Planning Application M/41/18 – Case Officer Zac Denton

25 Sea Way, Middleton on Sea

PROPOSED ELEVATIONS

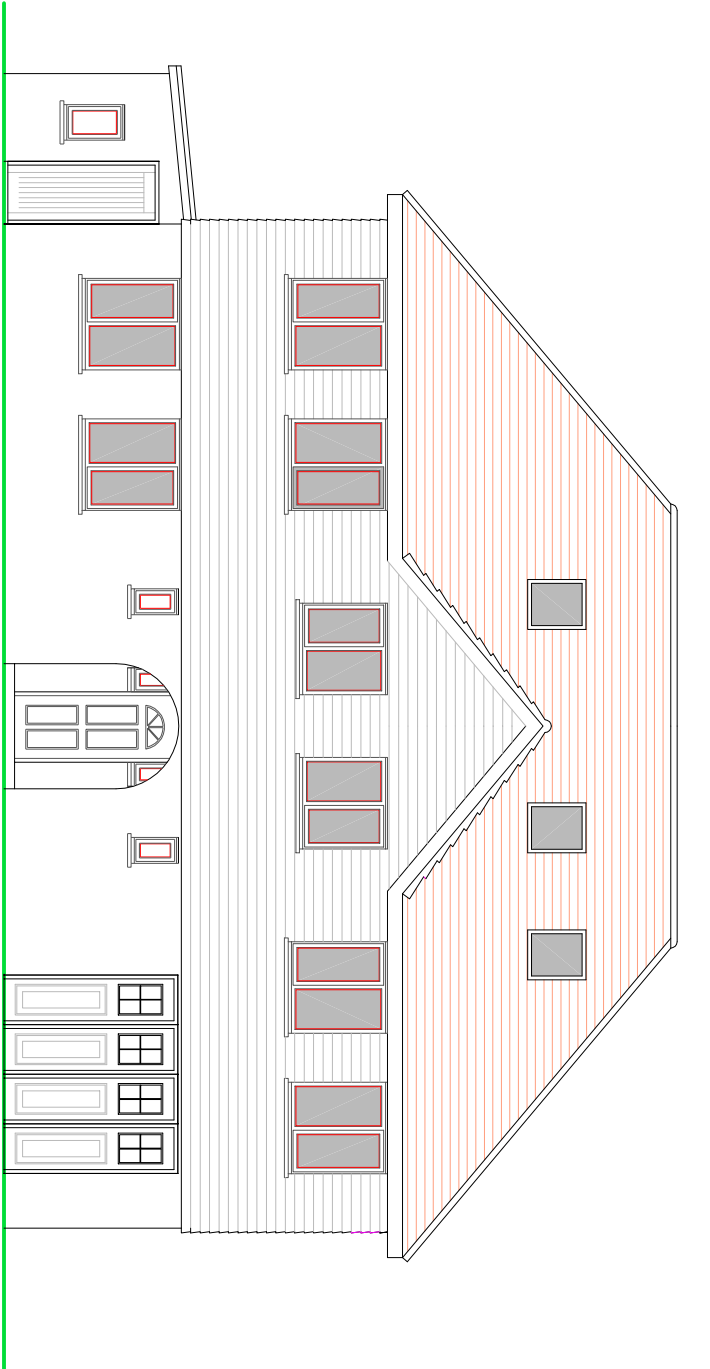
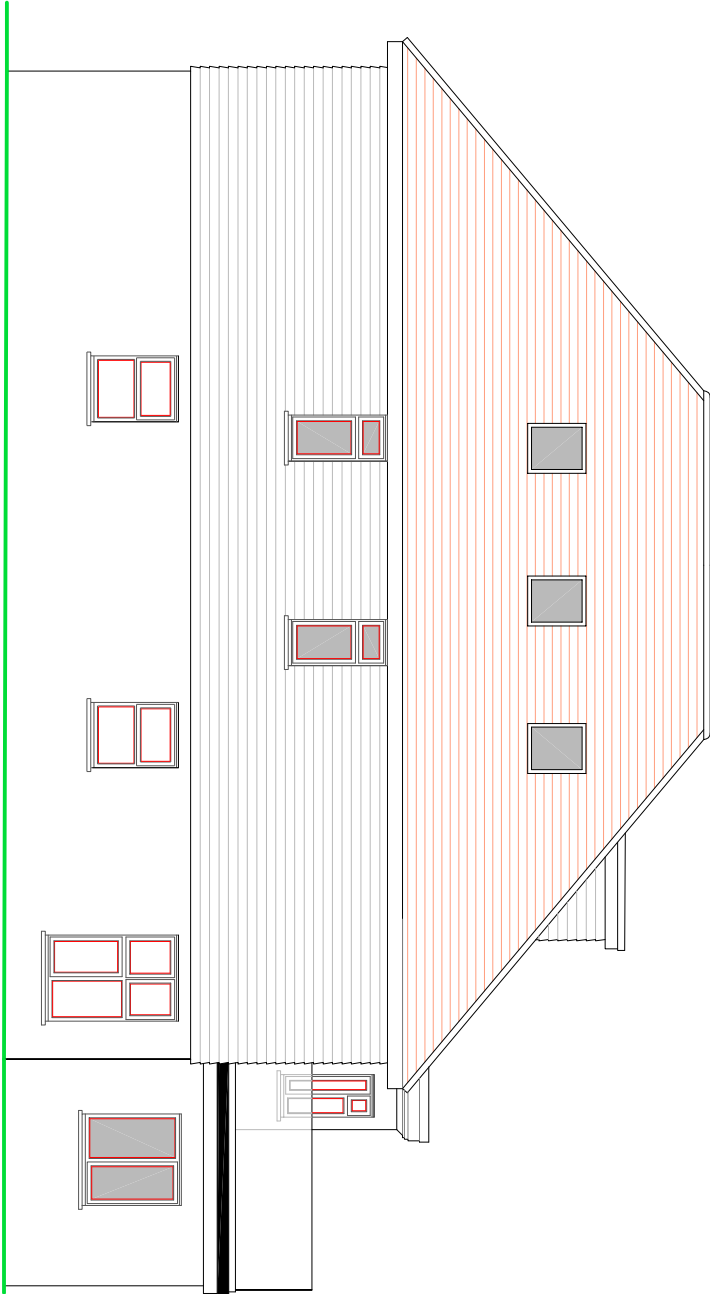
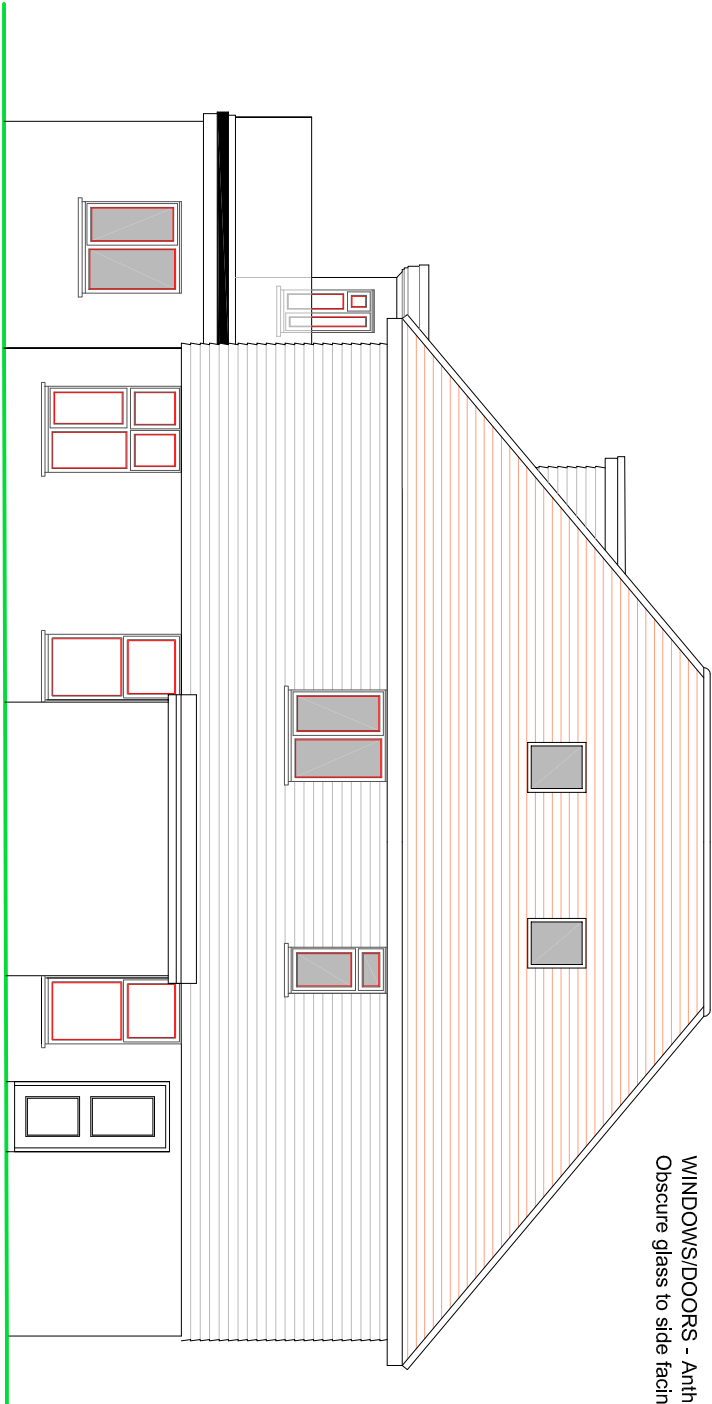
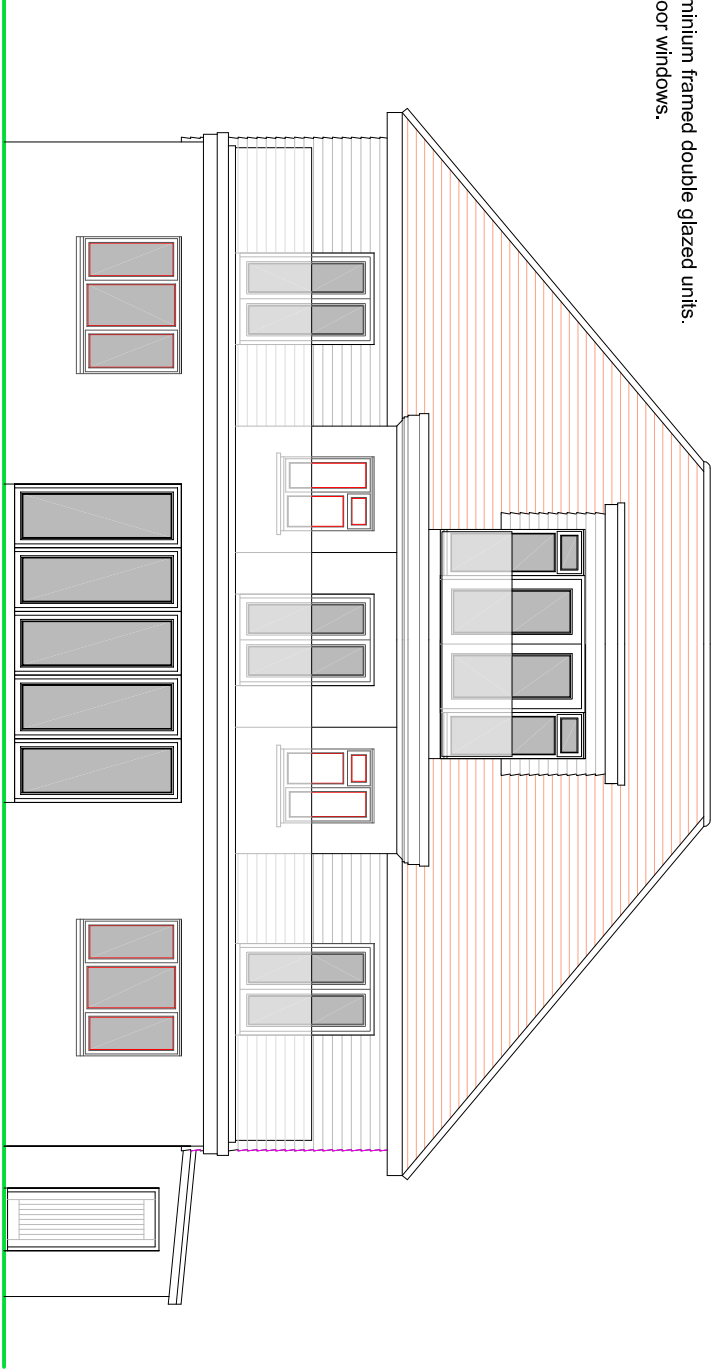
The plans show that there would be a large sun terrace created that would overlook and dominate nearby houses. It would create an intrusion for neighbours who would be overlooked and would lose privacy in the back gardens. To create that upper level balcony/terrace there would be a significant overall gain in the height and mass of the completed building.

The height, scale and several other features would be out of keeping with other properties in Sea Way and therefore in conflict with ADC Planning Policies.

There is a Design Statement for Middleton on Sea, approved and adopted by Arun District Council. On page 20 there is a requirement that alterations to existing buildings must comply with that supplementary planning guidance. The Design Statement requires that the scale of developments should be in keeping with the scale of existing properties. The changes proposed for 25 Sea Way would not be in keeping. The increased height would result in the roofscape with neighbouring properties not being maintained.
